Application H08-0657-24
Location Land off York Gardens Gosberton Spalding PE11 4HT
Proposal Details of external materials, biodiversity net gain plan, estate road phasing & completion plan, ground gas protection measures, contamination of land or pollution of controlled waters, archaeological investigation, equipped children's play area, site levels & floor levels, surface water drainage scheme, foul water disposal, construction management plan & method statement, prevent the deposit of mud on public highways, landscaping & tree planting, boundary treatments & management & maintenance schedule (Conditions 3, 5, 6, 7, 8, 10, 13, 15, 16, 17, 19, 20, 22, 23 & 24 of H08-1256-21)

Name Oliver Abrams
Address SHDC Environmental Protection Officer

Date Submitted 29-08-24
For/Against Comments

Site Investigation Plan

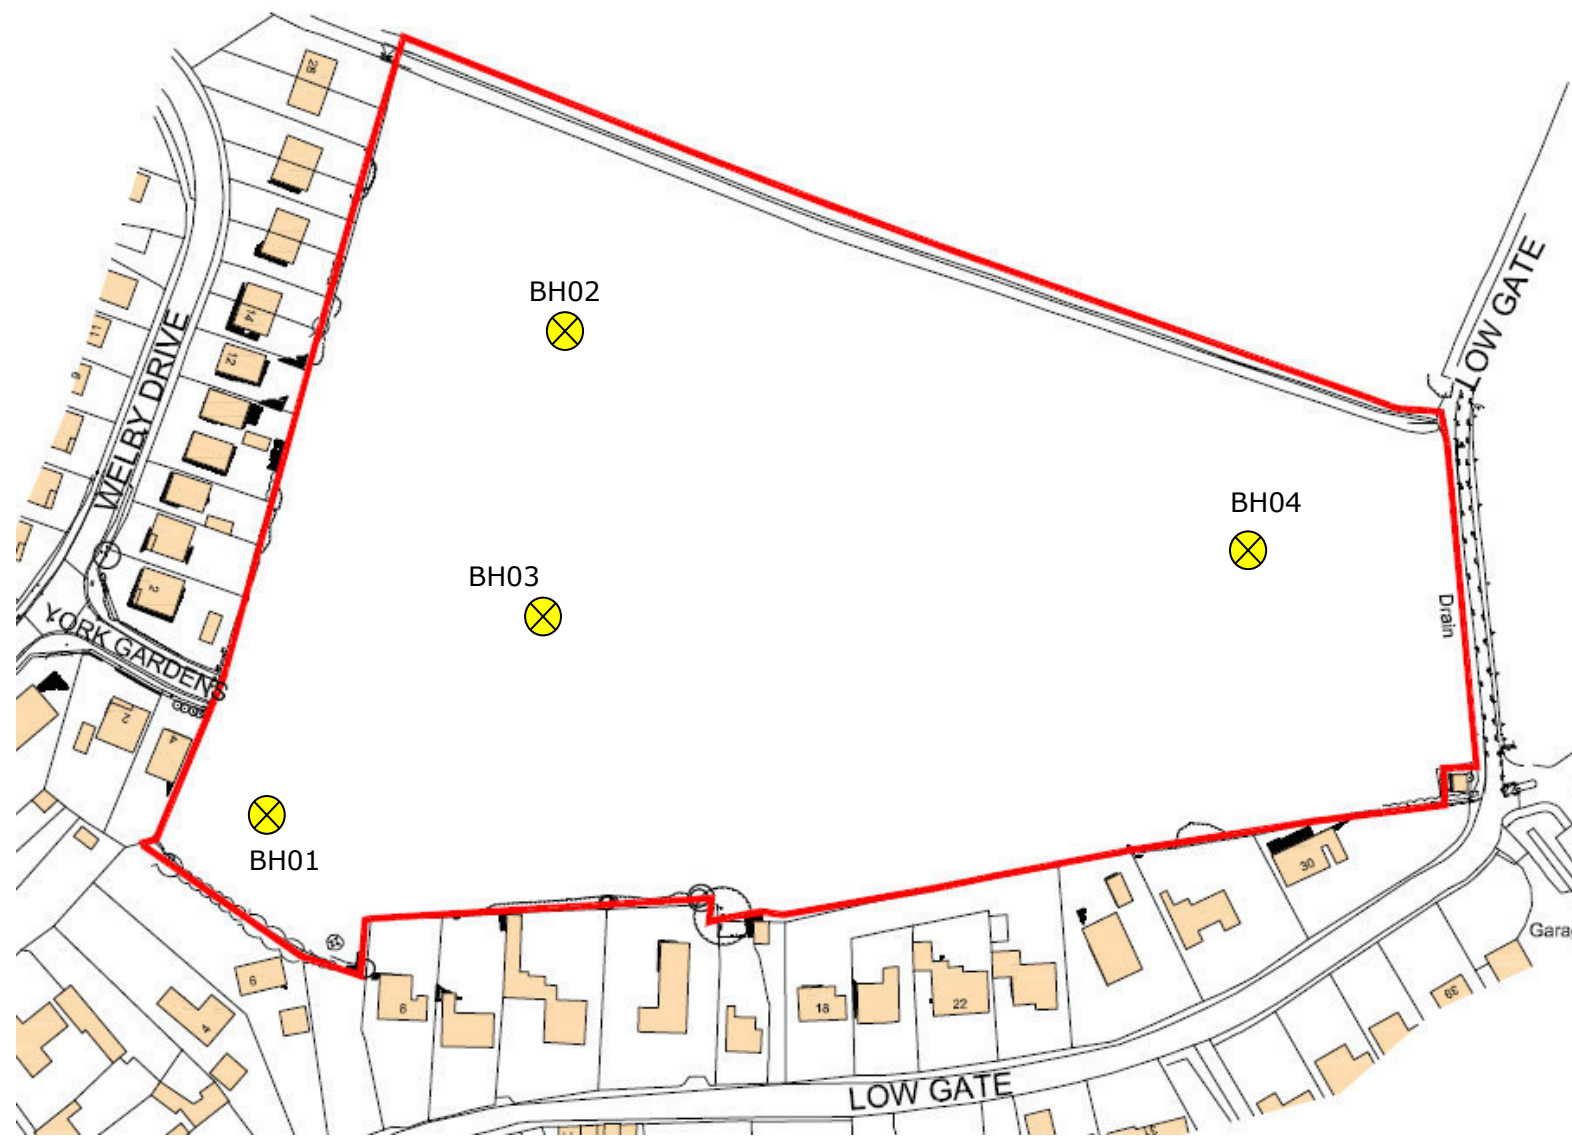
As highlighted in this report ground gas protection measures should be undertaken throughout this development. Also as highlighted in this report contamination found in soil samples of TP08, will require remediation as suggested in this report.

I request to see a validation report for the removal of contaminated soil in and around TP08. I also request to see gas protection measures being undertaken for this development.
